July 15, 2020

***Legacy Church – Green Mountain Falls: Drainage Revision Memo***

LEGACY CHURCH
 GREEN MOUNTAIN FALLS, COLORADO
 GRADING AND EROSION CONTROL PLANS
 GRADING AND EROSION CONTROL PLAN

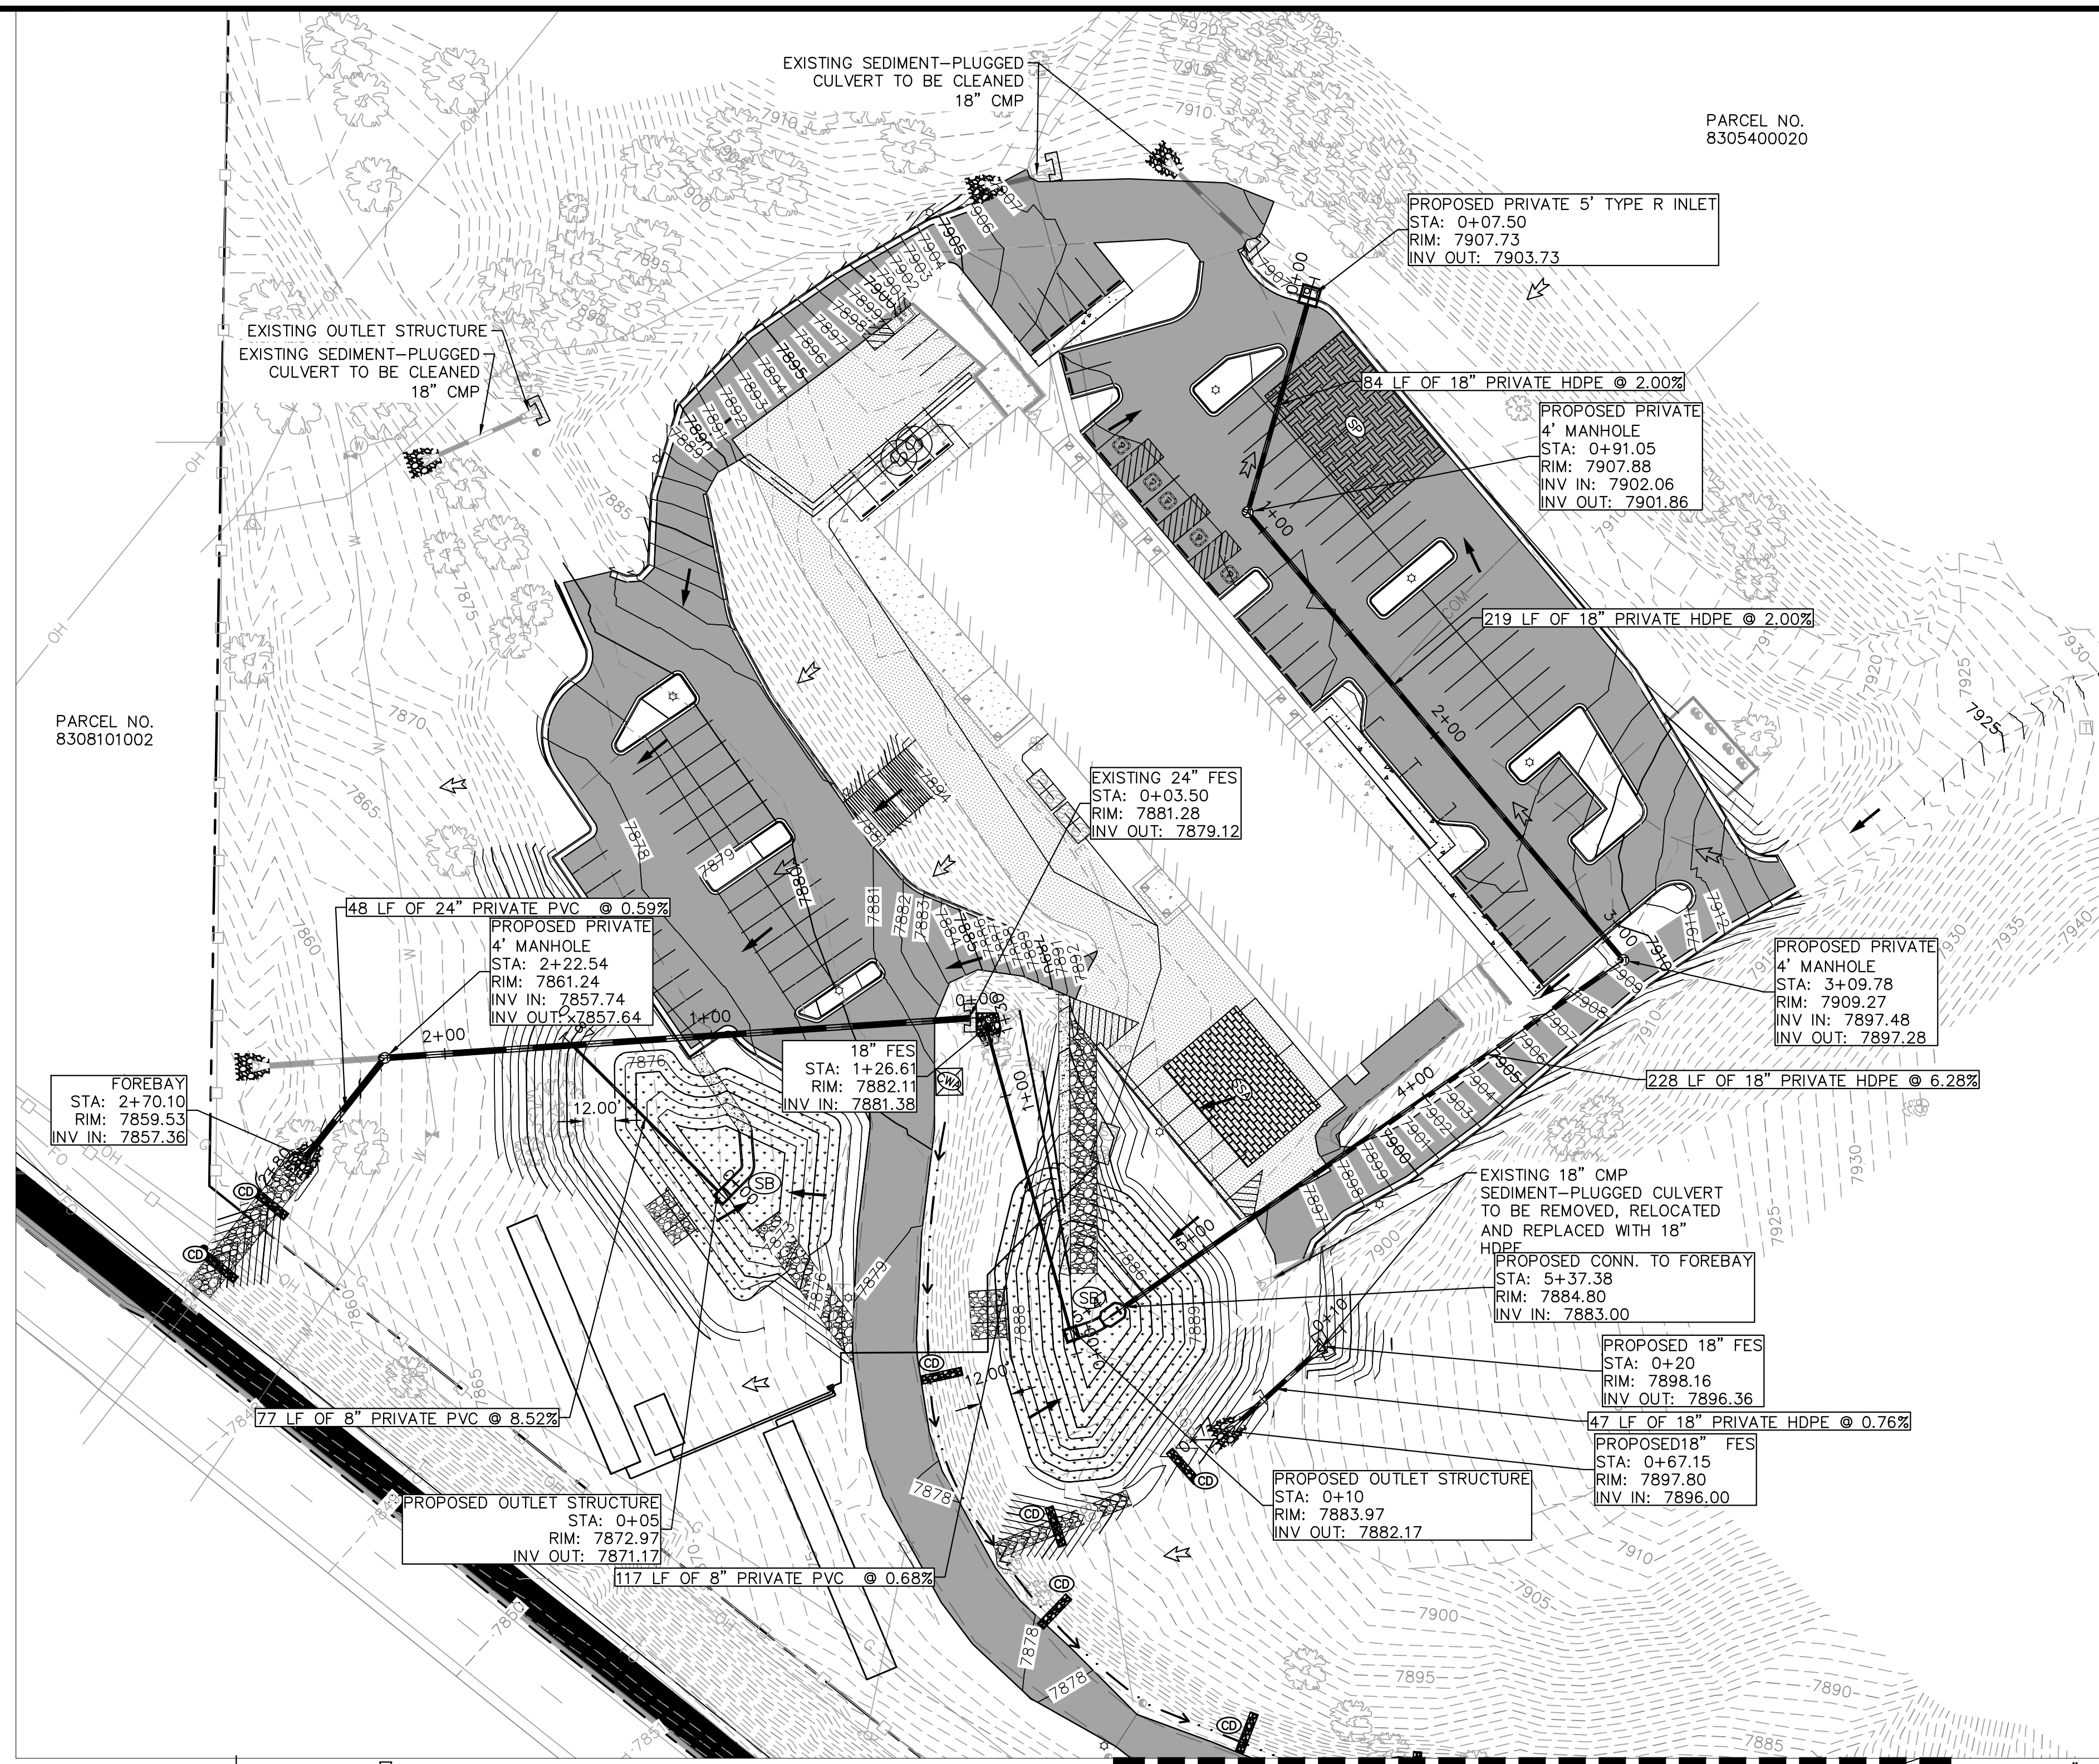
Thank you for discussing the minor changes associated with the Legacy Church – Green Mountain Falls project. The intent of this memo is to discuss the minor revisions made to the site plan and erosion control plan (which will be uploaded in concurrence with this letter), as well as to confirm the adequacy of the current storm sewer and detention pond systems with these revisions.

LEGACY CHURCH
GREEN MOUNTAIN FALLS, COLORADO
GRADING AND EROSION CONTROL PLANS
STORM SEWER PLAN

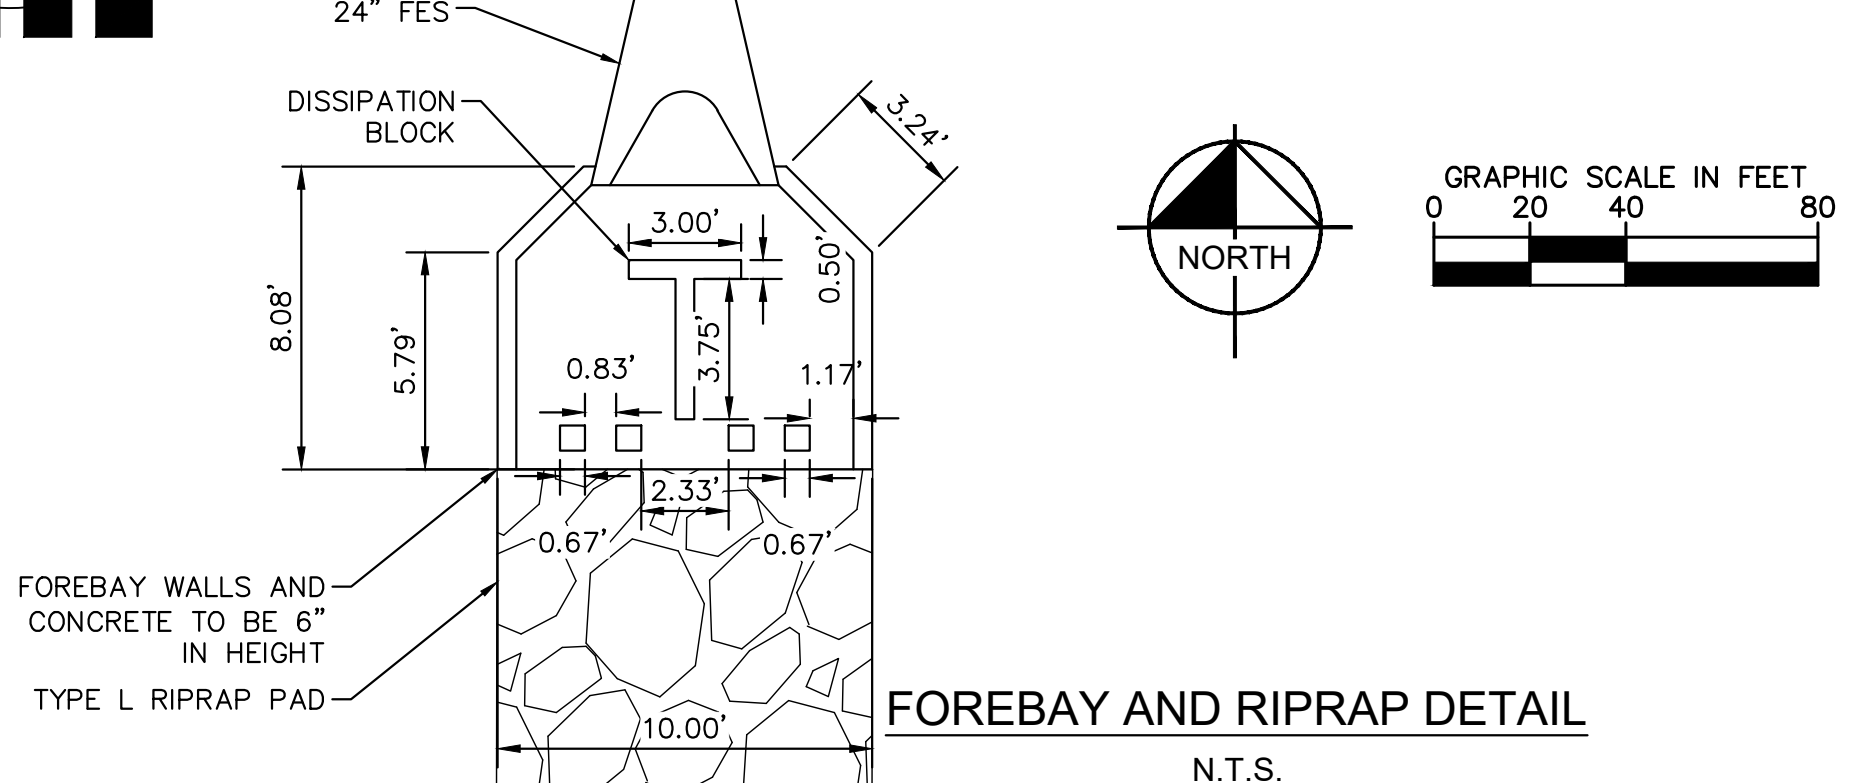
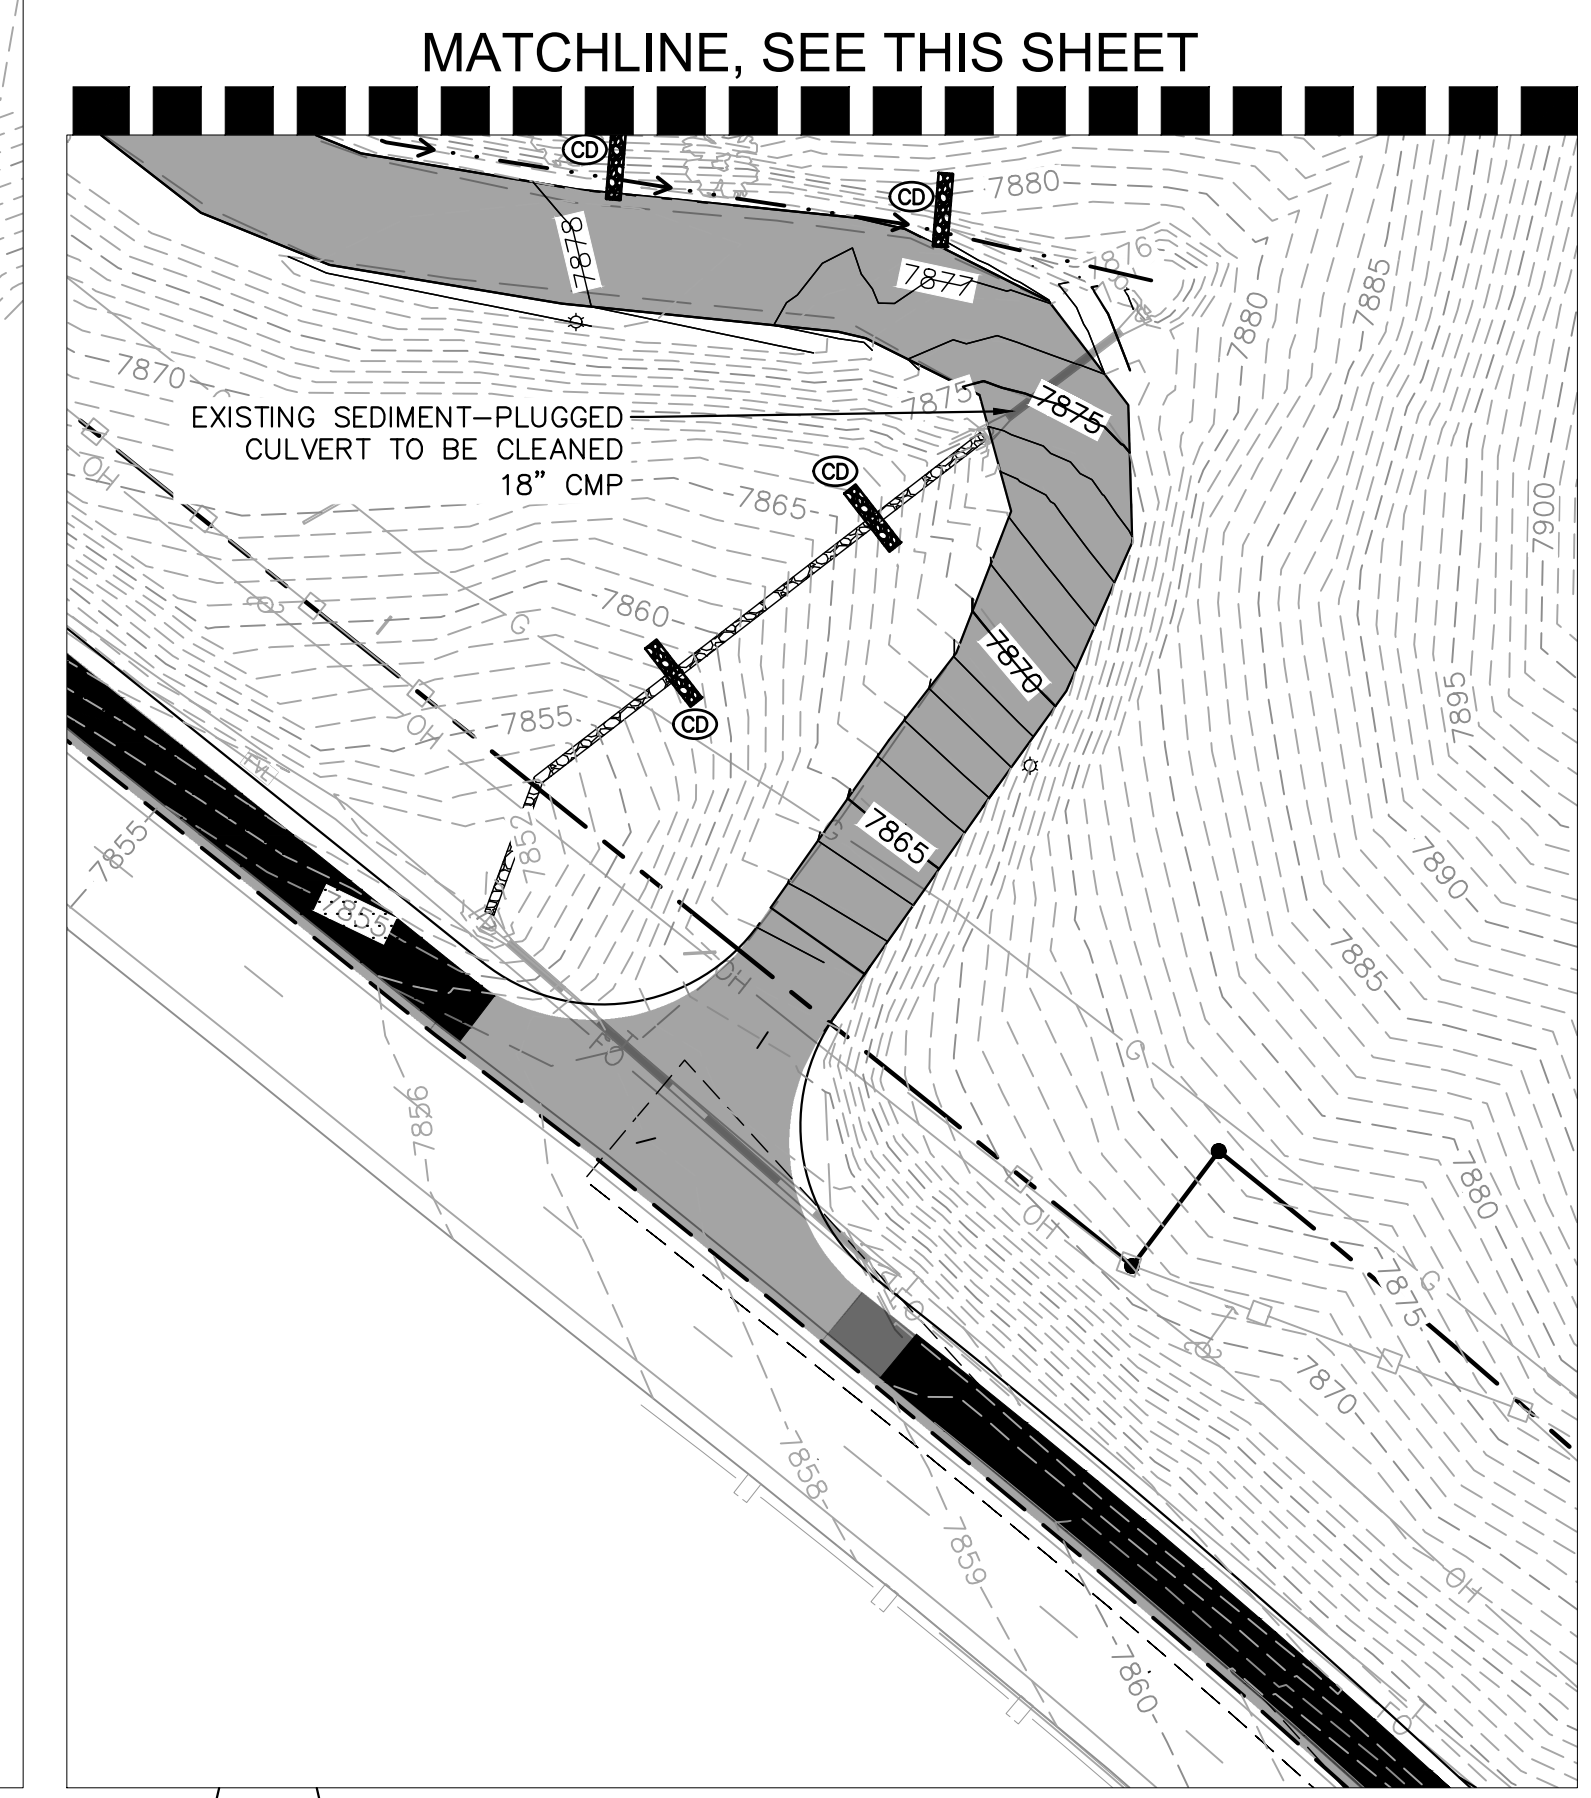
6. Pipes called out as 18" RCP on site has been updated to read 18" HDPE. These updates were made for cost and constructability purposes. These pipe changes do not adversely affect the proposed detention pond and storm design. Additionally, the change in piping will remain adequate for the developed/designed flows on-site.
